**Aldi Store, Hostmoor Avenue, March****CCC Ref: FDC 1991****TRANSPORTATION COMMENTS****PREPARED BY: Transport Assessment Team****AUTHOR: Hannah Seymour-Shove****CHECKED BY: David Allatt****DATE: 8<sup>th</sup> December 2020****Background**

These comments concern the TN05 - Existing Traffic Data Assessment dated 20<sup>th</sup> November 2020 produced by Connect Consultants Ltd. The proposals comprise the development of a new Aldi discount foodstore with GIA of 1881sqm on Hostmoor Avenue in March.

These comments concern the TN04 - Traffic Signal Junction Capacity Assessment dated 12<sup>th</sup> November 2020 produced by Connect Consultants Ltd. The proposals comprise the development of a new Aldi discount foodstore with GIA of 1881sqm on Hostmoor Avenue in March.

Appendix 2 – Proposed Signal Junction Layout Sketch

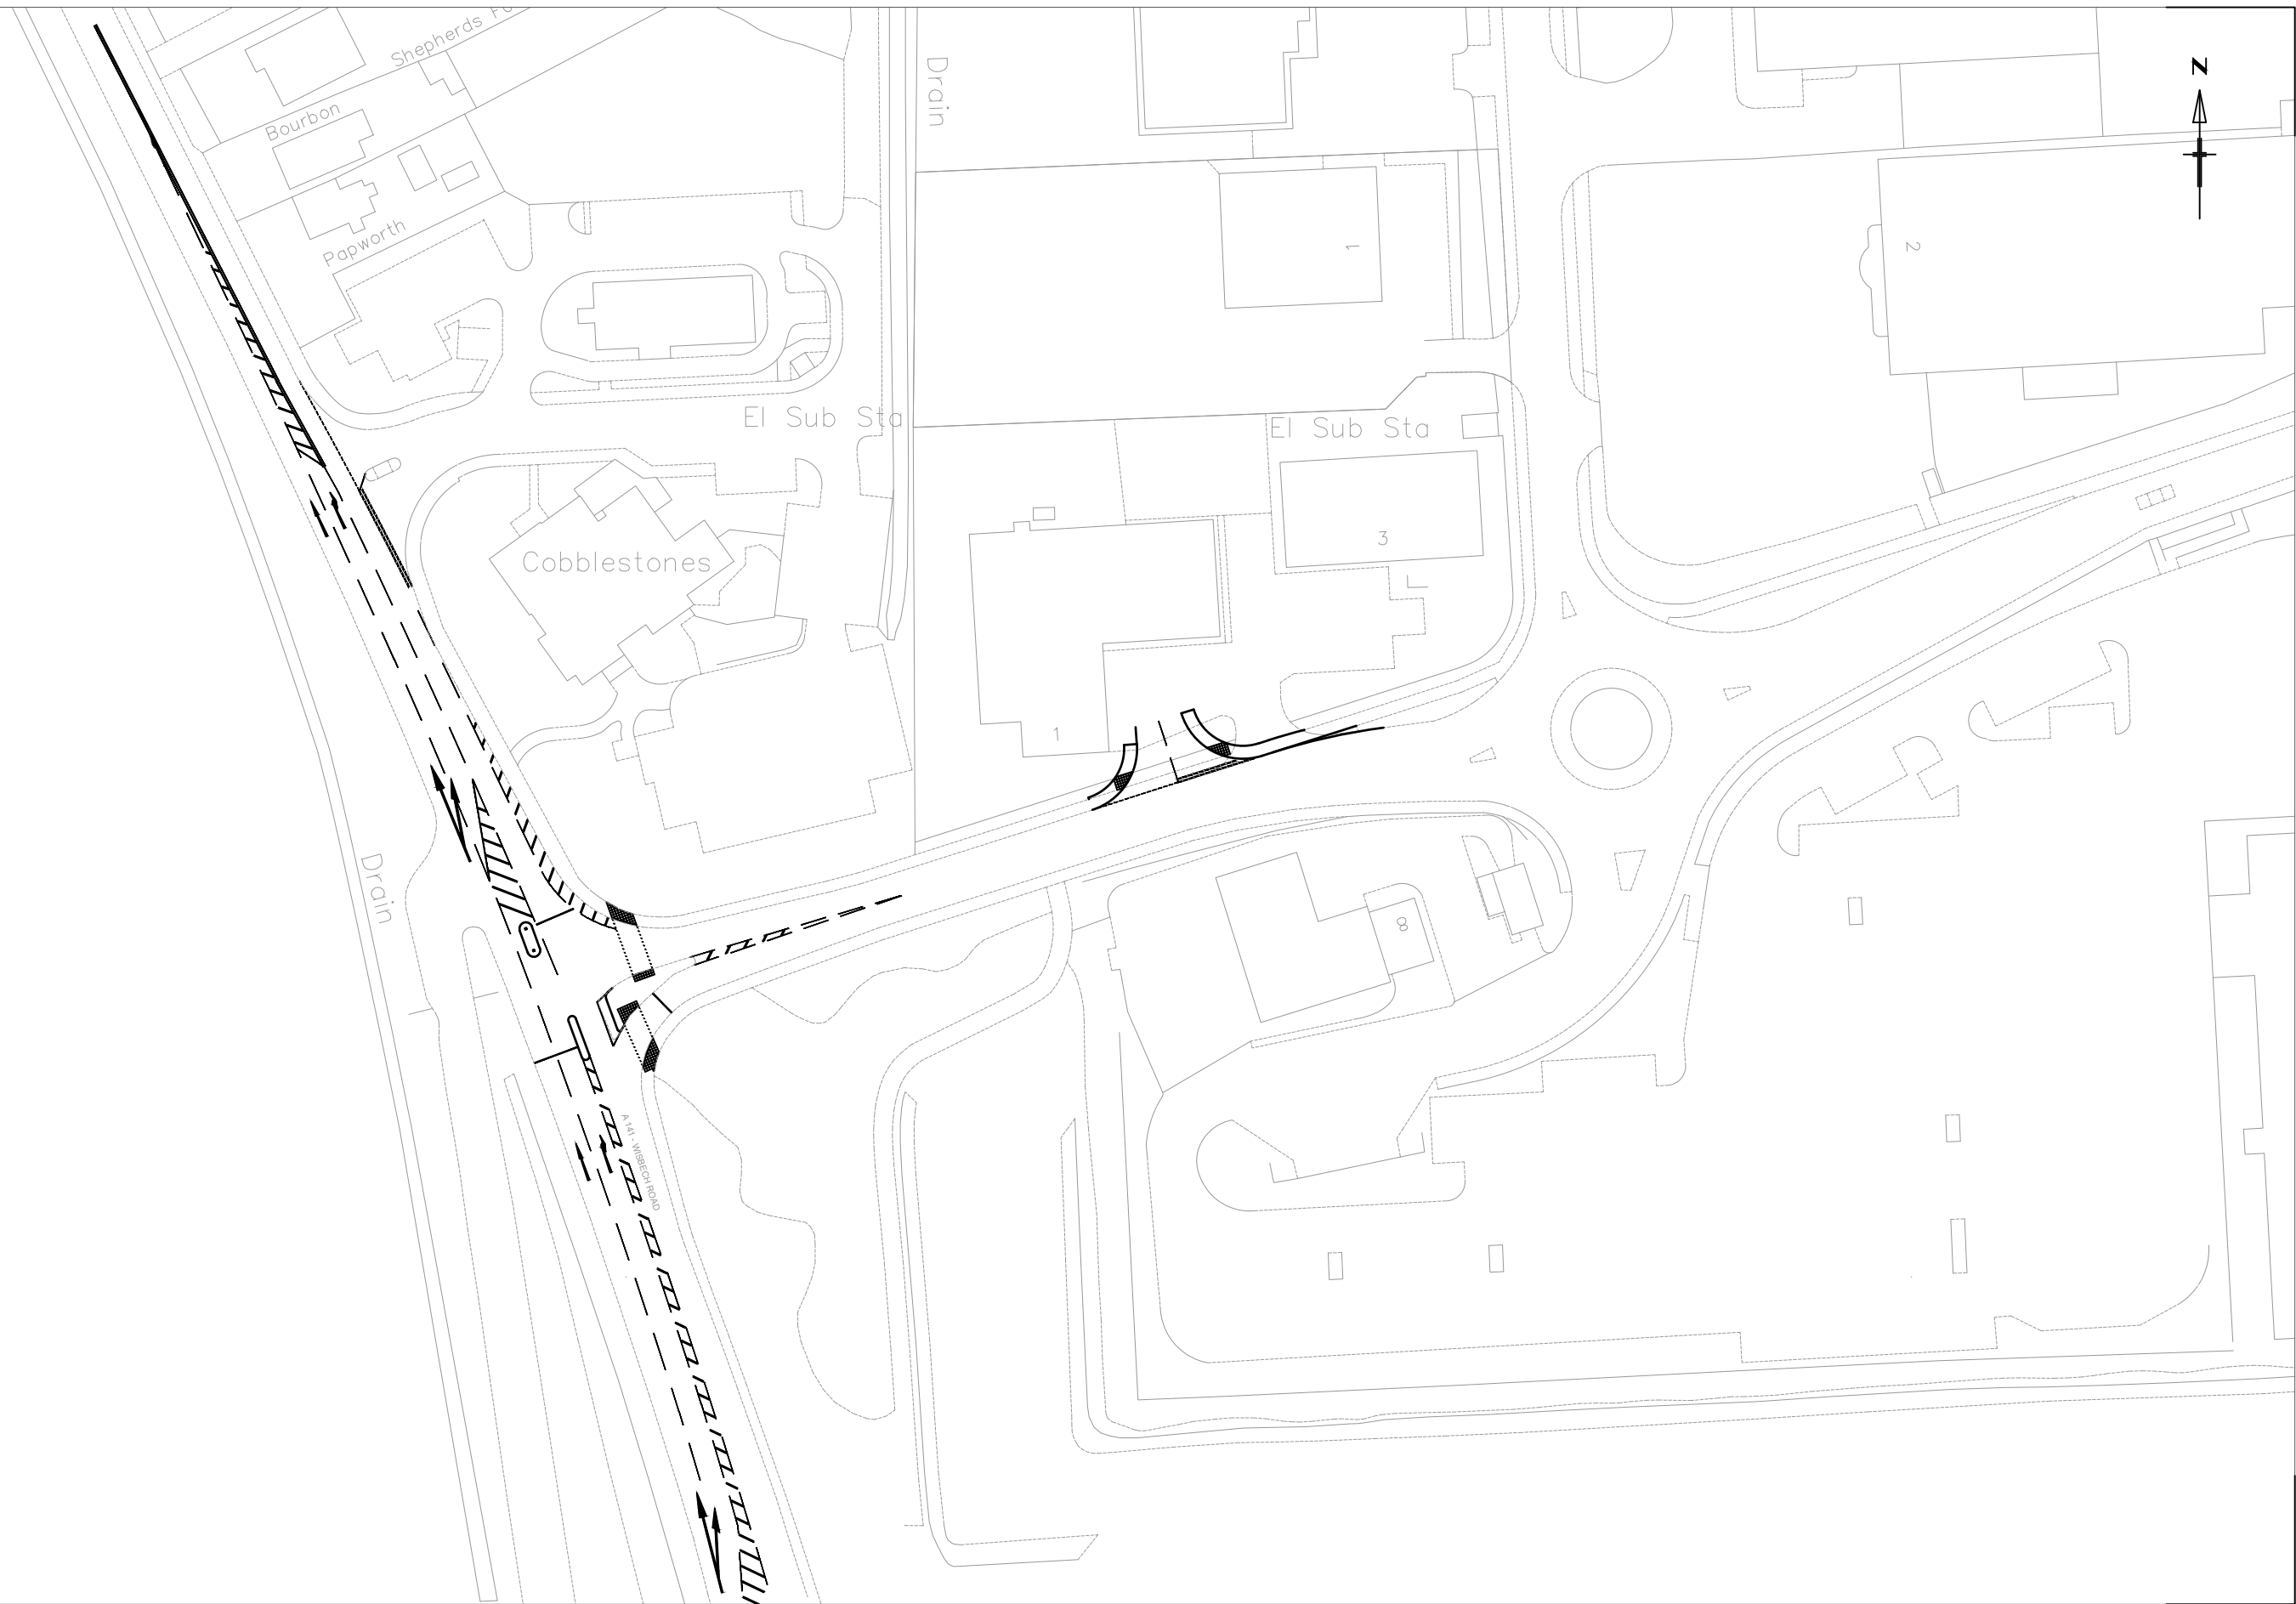
- *The McDonalds access as indicated on the flow diagram is very close to the A141. These stores have been shown to cause great disruption to the network due to queuing back, this has been especially an issue during the recent Covid times. The right turn from Hostmoor Avenue into the McDonalds could experience queueing on Hostmoor Avenue going back onto the A141.*

- General proposal layout - Somebody leaving Hostmoor and wanting to head north up the A141 are going to be forced out left. The suggestion is that they will then use the roundabout to U-turn. If this is the chosen option, to prevent drivers from coming out left and then performing a dangerous manoeuvre to turn immediately right after the island and approach the northbound lane to the signals to avoid U-turning at the roundabout, then an island would be required connecting all the way to the roundabout, with a barrier to stop people driving over the central kerb. A Safety Audit is likely required at the planning application stage to assess the safety of this junction design.

- The forced left turn also complicates any future expansion into the land opposite which would require a fourth arm. If a fourth arm was added to the junction in the future, the junction would likely be heavily over capacity. It would be better to access development on the land opposite from another location.

- At a basic level it looks like the right turn has been taken away from Hostmoor Avenue because if left in the design then the signals would need another stage, leading to the junction being over capacity.

- Evidence would be required to determine whether the additional Hostmoor Traffic U-turning at the roundabout below would cause capacity issues at such roundabout.

Network Layout Diagram

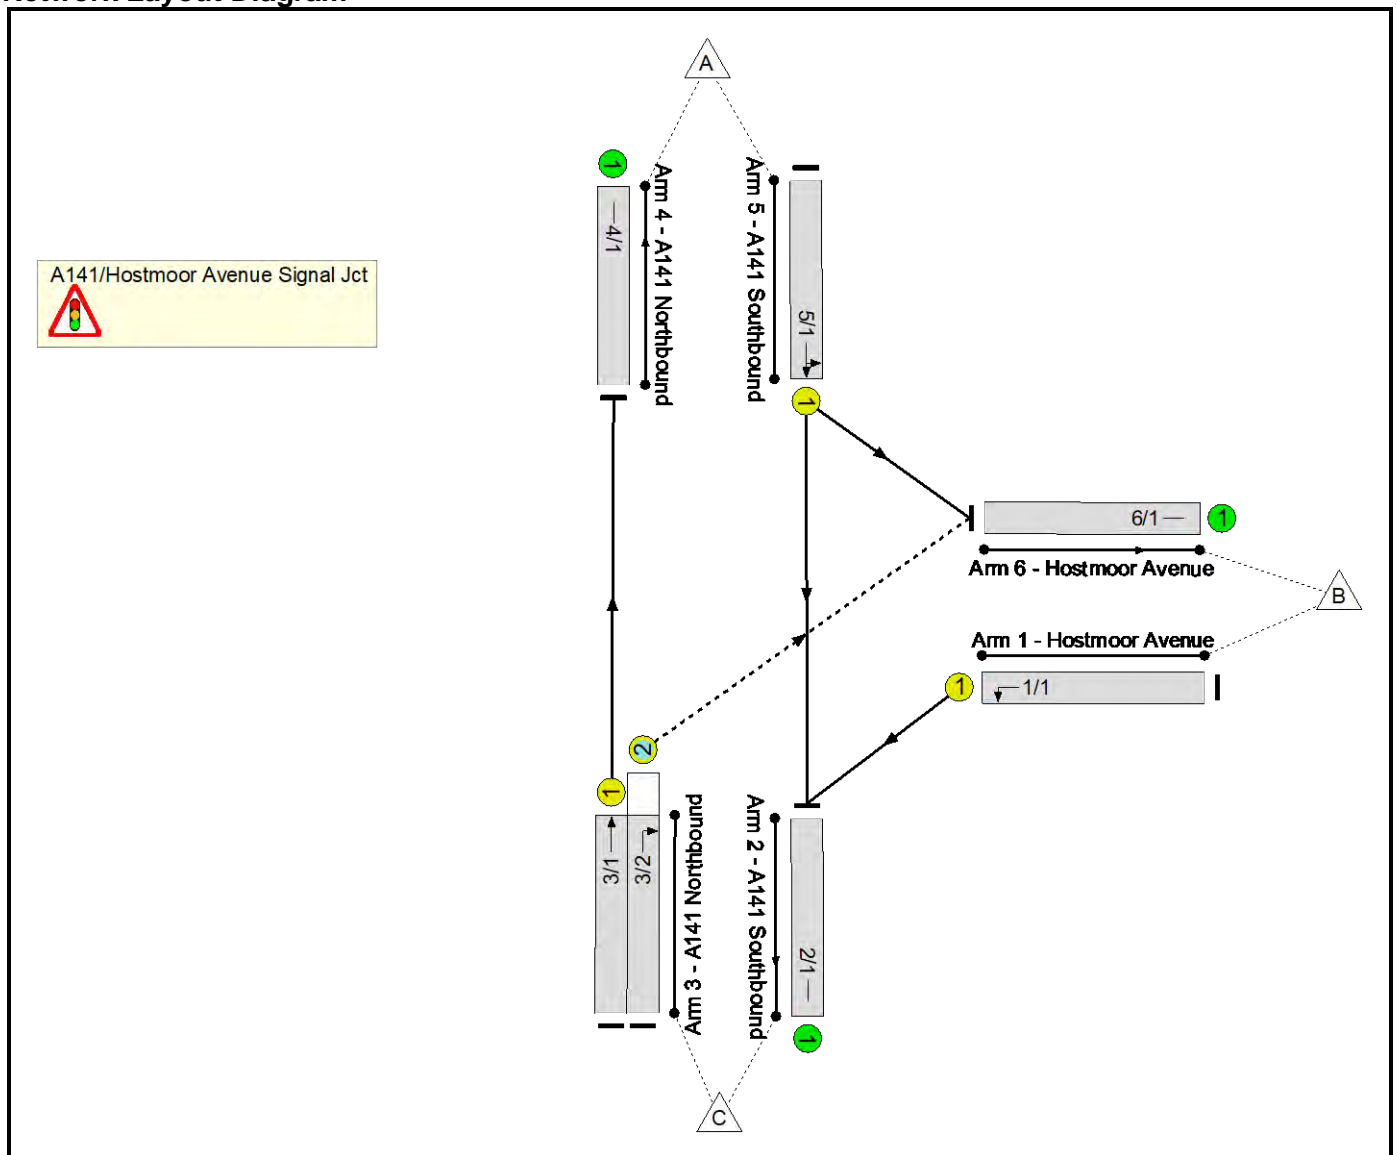
- The LinSig model submitted is not acceptable. It is not presented as a realistic working junction.
- The inter-greens in the LinSig matrix do not match reality, all vehicles ones are 5, all pedestrians 9.

- Of note is that the northbound approach to the signals will always be green as there are no conflicts, OK we have this on the A10.
- There is a problem with the staging. Pedestrian phases D and E are shown as not running in any stage. There would need to be an agreement on how often they need to run per hour in the model but not running at all is incorrect.

- The model has information about the right turn being gap accepting in one place and fully signalled in another, gap accepting is not acceptable.
- In para 2.2 there is a comment that 100% "represents a situation where a link is operating at its theoretical capacity". Whilst this is correct, at 100% in a model, there will be times when the network in practice would be overloaded. For this reason, we require a max 90% of capacity, to give 10% reserve capacity to cope with the high/lows of any peak period.

- *The lane width information inputted into the lane saturation flows looks wrong. On the southbound arm they have declared a 5m lane. It might be 5m at the stop line but as you get back up the link it narrows, in practice greatly reducing the saturation flow of the important link. Comparing this with other links I'd suggest the sat flow would go down from the 2082 to about 1990 vehicles per hour.*
